# KITTITAS COUNTY COMMUNITY DEVELOPMENT SERVICES

**Subject: Final Development Plan for the Vantage Bay PUD (File Z-06-00025 & LP-06-00026) – Staff Review and Request for Additional Information**

## Vantage Bay PUD Compliance Review

VANTAGE BAY, PLANNED UNIT DEVELOPMENT

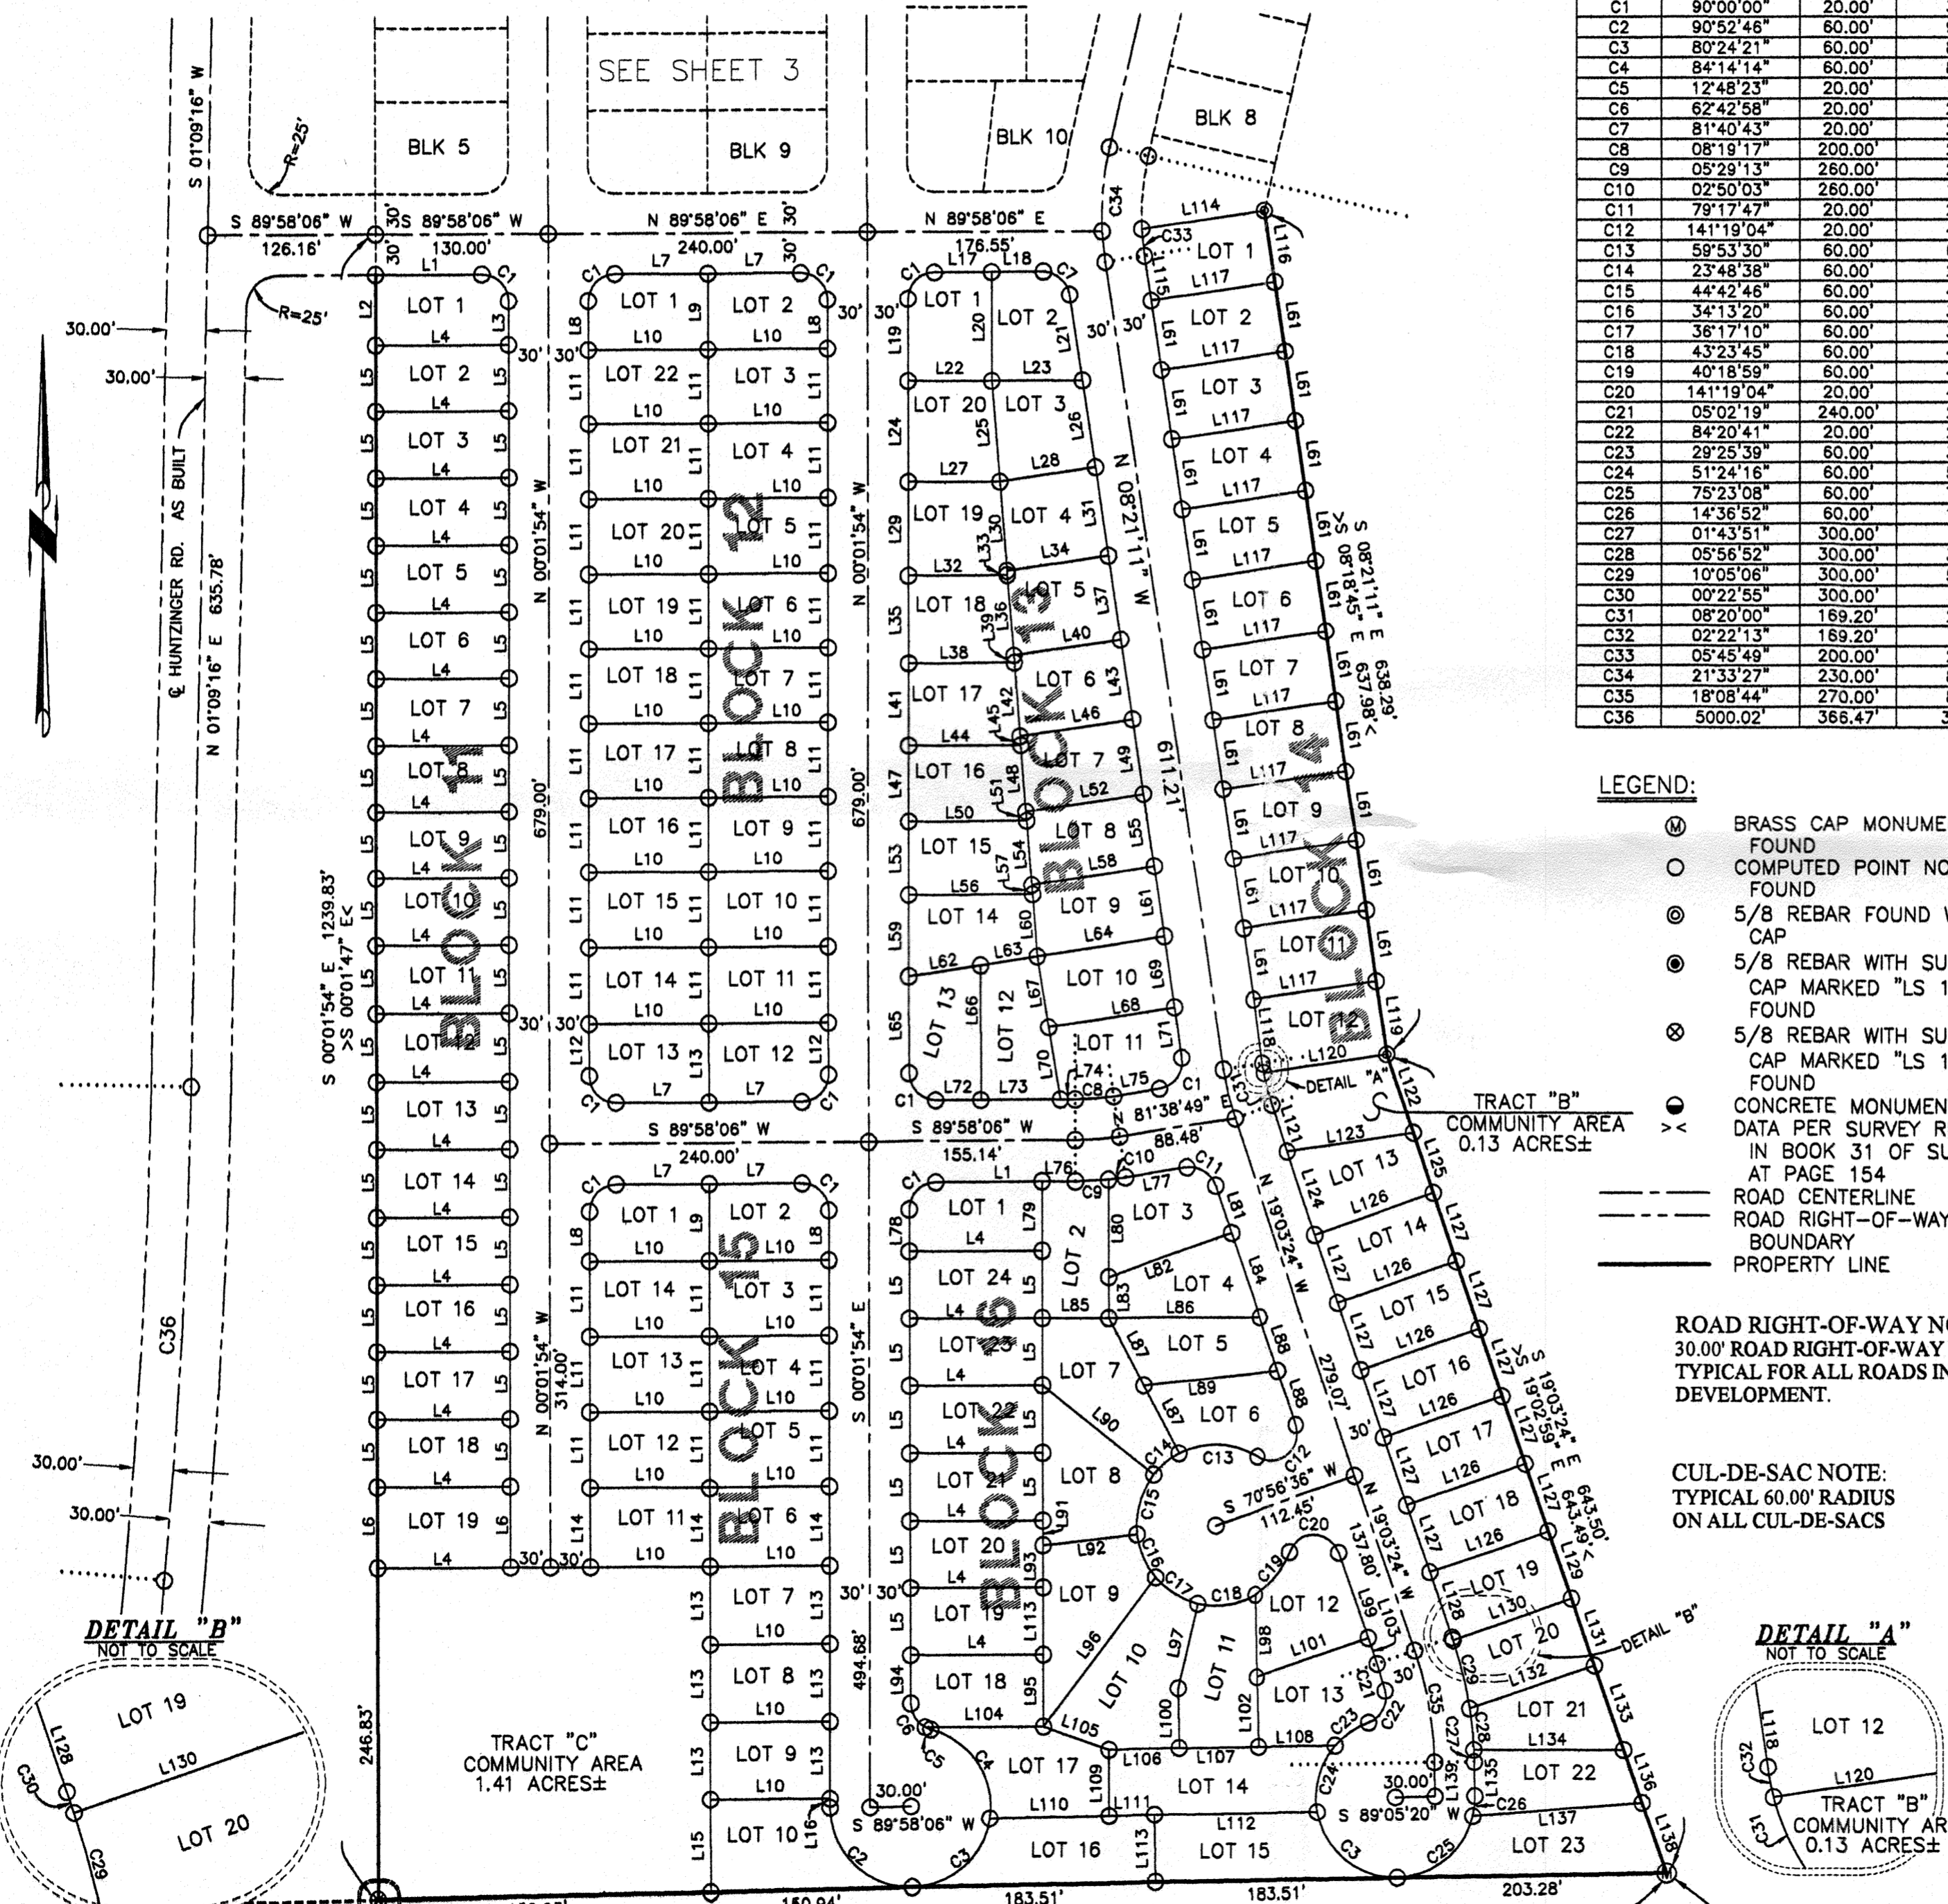
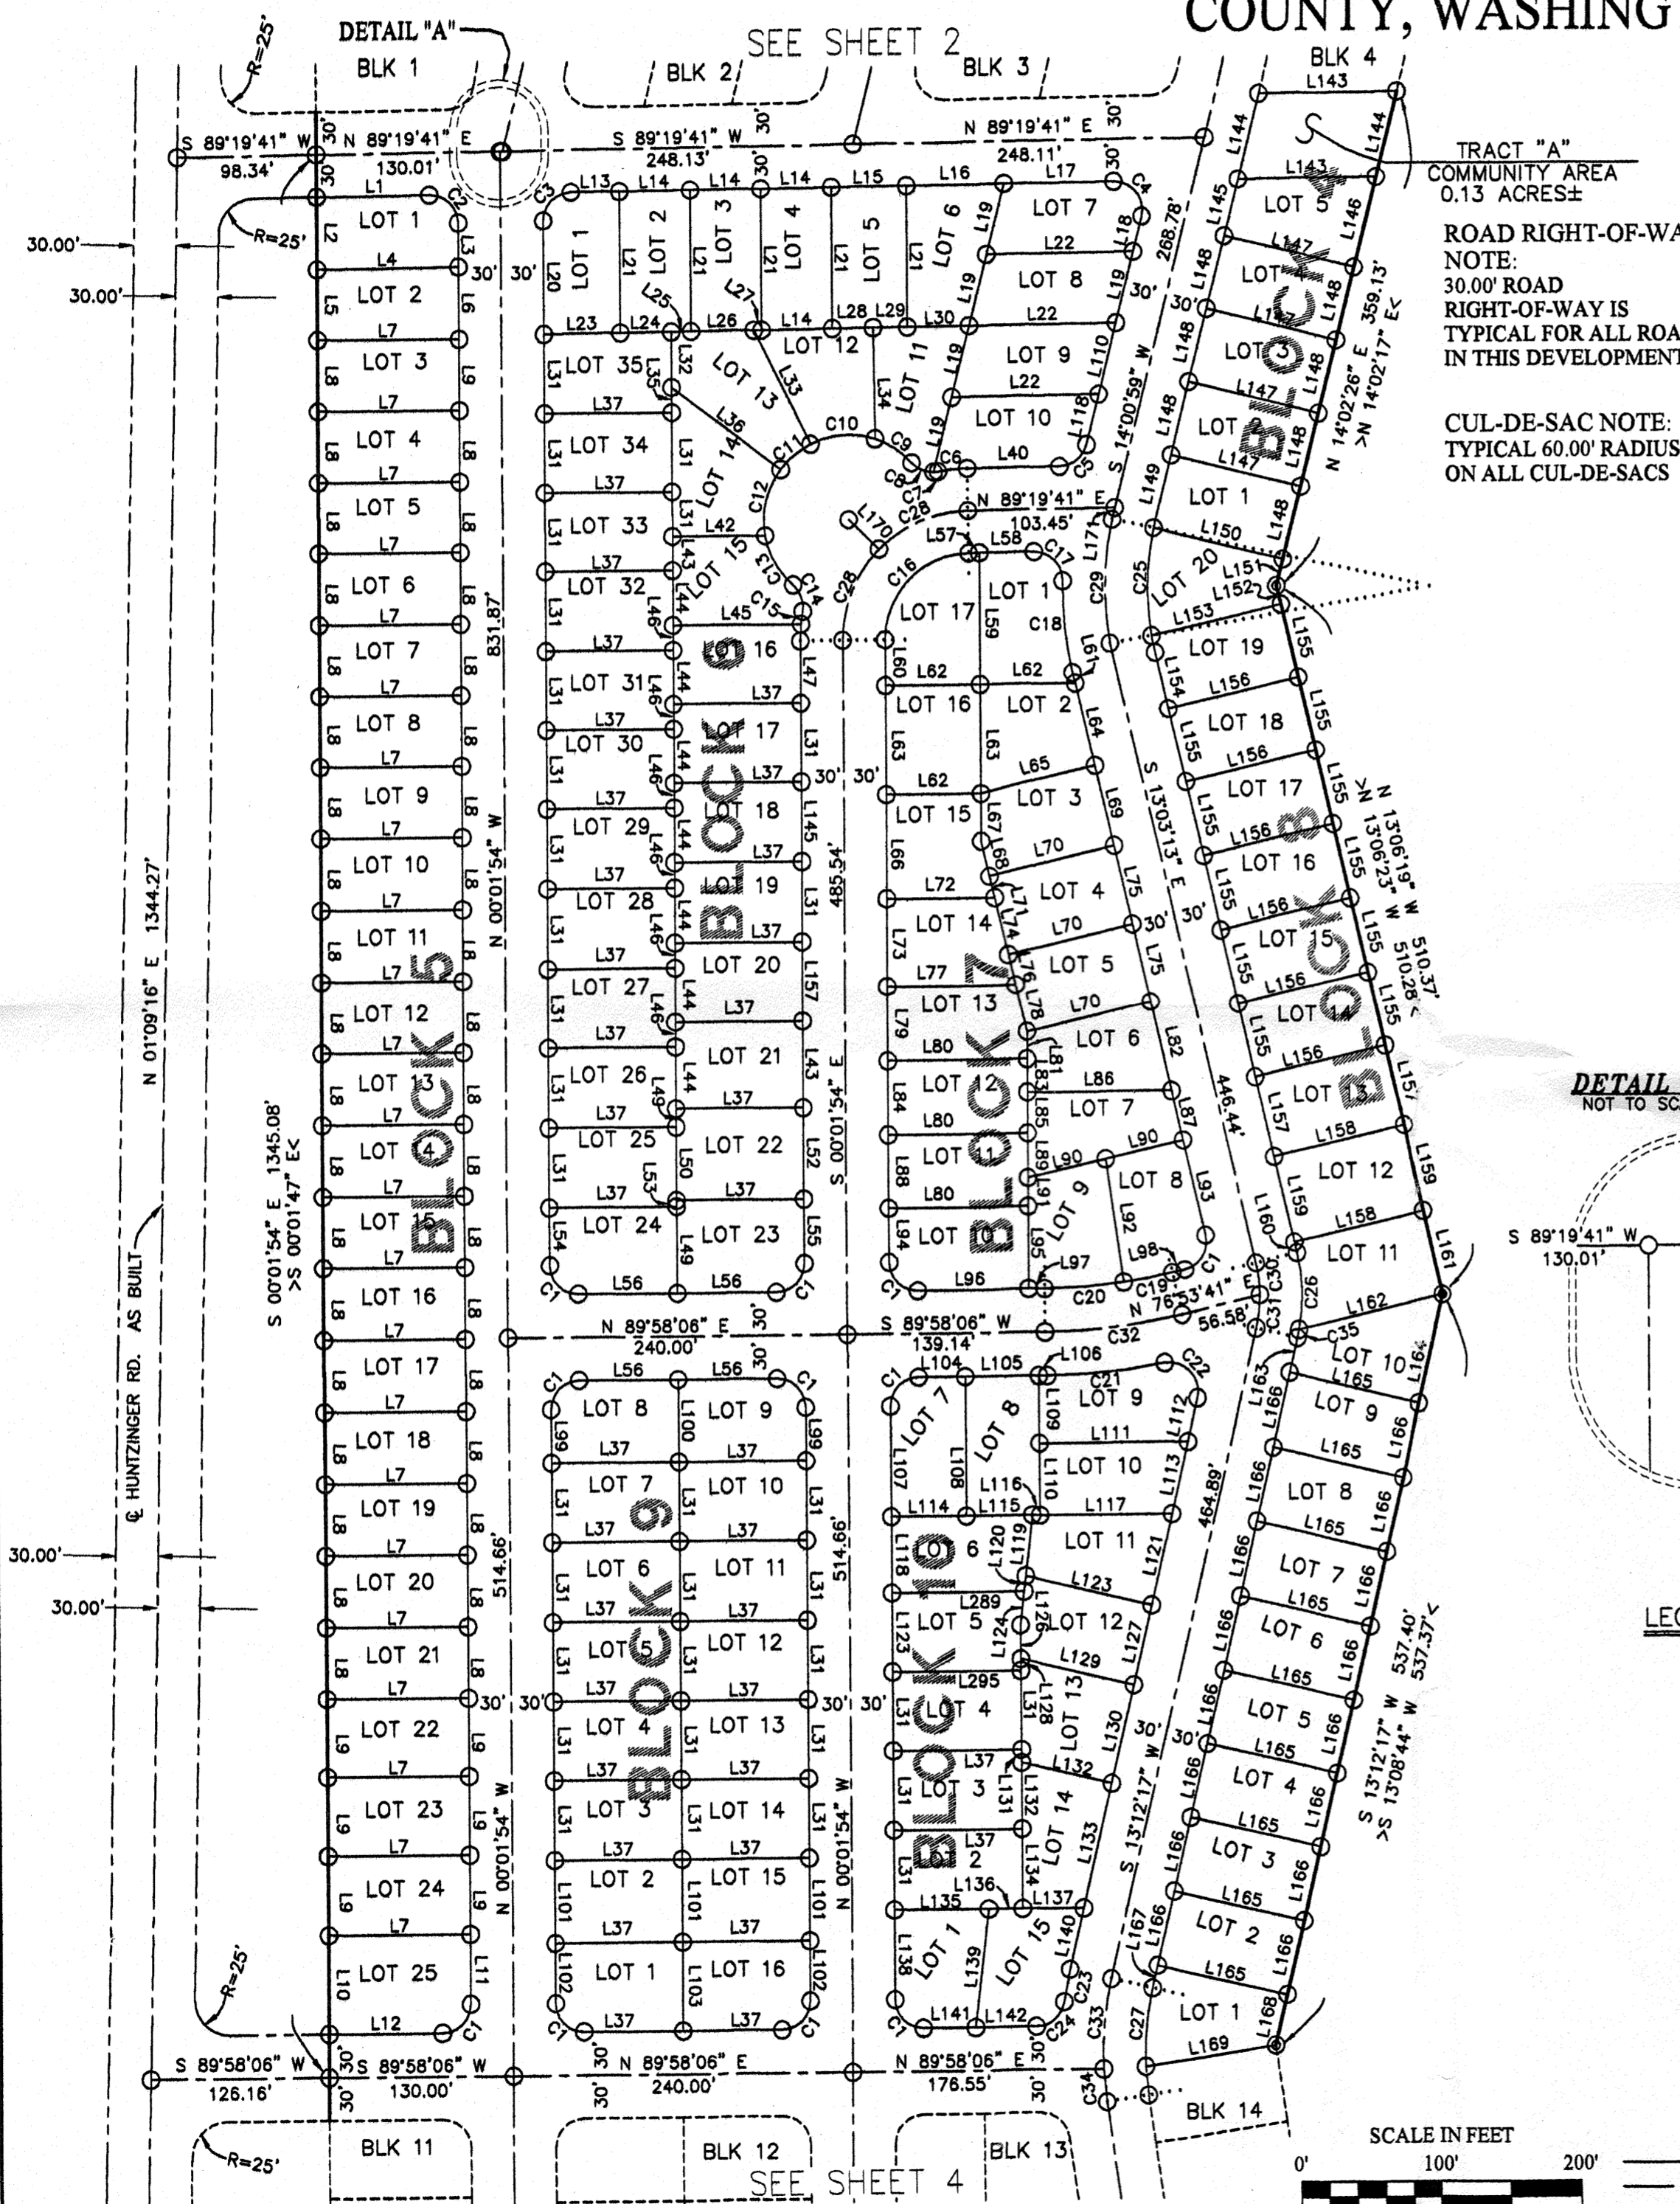
- Pursuant to KCC 17.36.040 (existing at the time of application), a map or maps of the site drawn at a scale no smaller than one hundred feet to one inch showing the following:
  - Public utilities; note review matrix section 1.b.i comments
  - Typical lot layout; note review matrix section 1.b.ii comments
  - Please provide driveway information; note review matrix section 1.b.v comments
  - Please provide open space locations, note review matrix section 1.b.vii
  - Please provide fire protection locations, note review matrix section 1.b.viii

Please provide updated mapping either with a key or identification on each building/area regarding the type/use.

Please provide contours to assist in review of the proposal for feasibility purposes. Final grading plan shall be addressed prior to final plat submittal.

maintained from the wetlands. Currently, the preliminary plat depicts a buffer that is over 120 feet from the wetlands. According to the preliminary approval condition, "Proper signage shall be incorporated and maintained on-site to encourage the maintenance of the buffer and natural condition of the shoreline and wetlands. The signage shall be interpretive in matter, and explains about the buffer integrity requirements and educates about the importance of the area for wildlife, etc. the applicant shall work with the Department of Ecology and County to design and establish the signage and a buffer restoration plan." Wetlands locations and buffer boundaries shall be delineated on the final mylar. A plat note shall be included on the final mylar stating that All development will need to comply with KCC 17A: Critical Areas; note review matrix section 2.j comments

Please either submit a Shoreline Substantial Development Permit application for review as required by ordinance No. 2006-60 or redesign project outside of the shoreline jurisdiction
